**JOINT RELEVANT REPRESENTATION REGARDING THE APPLICATION BY EQUINOR
NEW ENERGY LIMITED FOR AN ORDER GRANTING DEVELOPMENT CONSENT FOR
THE SHERINGHAM AND DUDGEON EXTENSION PROJECTS**

PLANNING INSPECTORATE REFERENCE EN010109

RELEVANT REPRESENTATION MADE ON BEHALF OF:

DATE OF REPRESENTATIONS: 14 NOVEMBER 2022

Land Subject to Temporary Occupation and Use and Acquisition of Permanent Rights
02-010; 02-011; 02-012; 02-013; 02-015; 03-003; 03-004; 03-008; 03-009; 03-010; 03-011

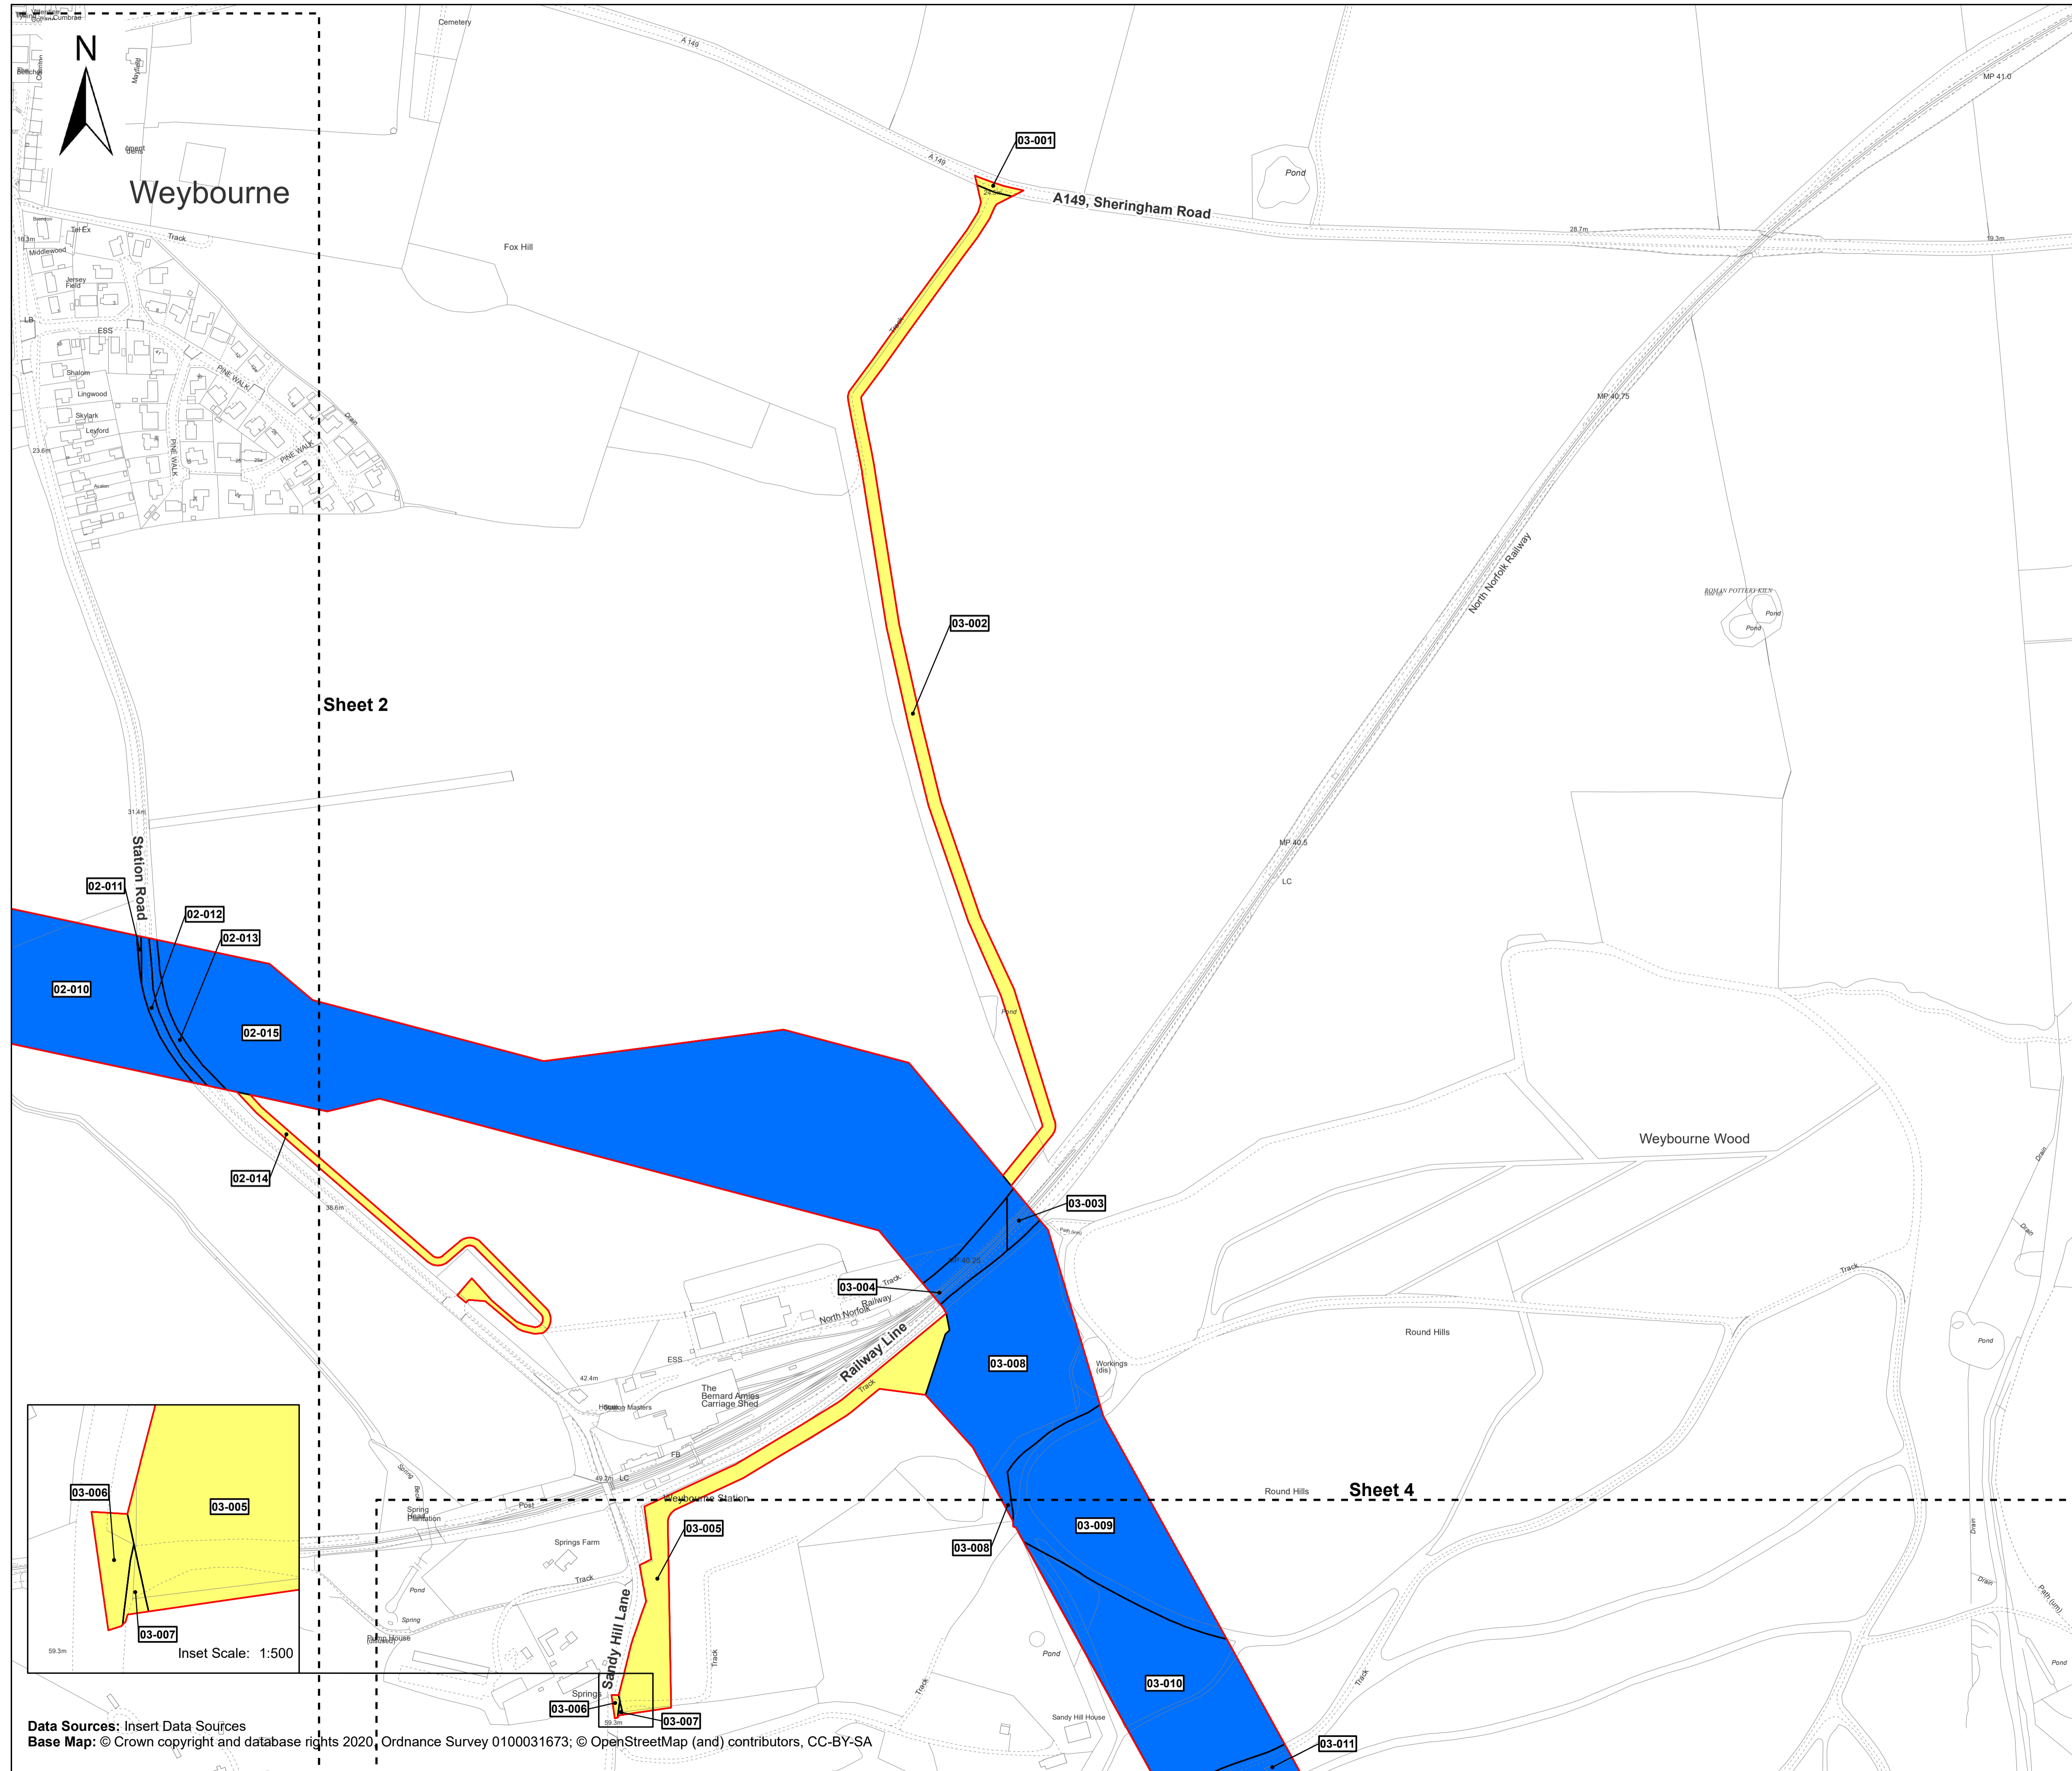
9. The Book of Reference [APP-026] records Our Clients’ interests in the following plots as shown on the Revision B Land Plans [AS-002]:
 - 9.1. Mr Hay-Smith:

- 9.1.1. Acquisition of rights in the following plots: 02-002, 02-006, 02-010, 02,012, 02-015, 03-008, 03-010 and 04-003.
 - 9.1.2. Temporary possession: 02-007, 02-008, 02-009, 02-014, 03-001, 03-002, 03-005, 03-006, 03-007, 04-002, 04-004, 04-011 and 04-013.

- 17.5. Routing of the onshore cables across the Station Road/Sandy Hill Lane roadway will further exacerbate the environmental impact on native trees and hedgerows to both the east and west of the road which forms a critical entry point to the village of Weybourne.

- 17.6. The routing of the onshore cables will also severely impact the safety and business operation of the Station Road farm service road and buildings as the cable would run parallel to the farm's entrance splay, service road, grain dryer, timber storage yard and equipment shed.
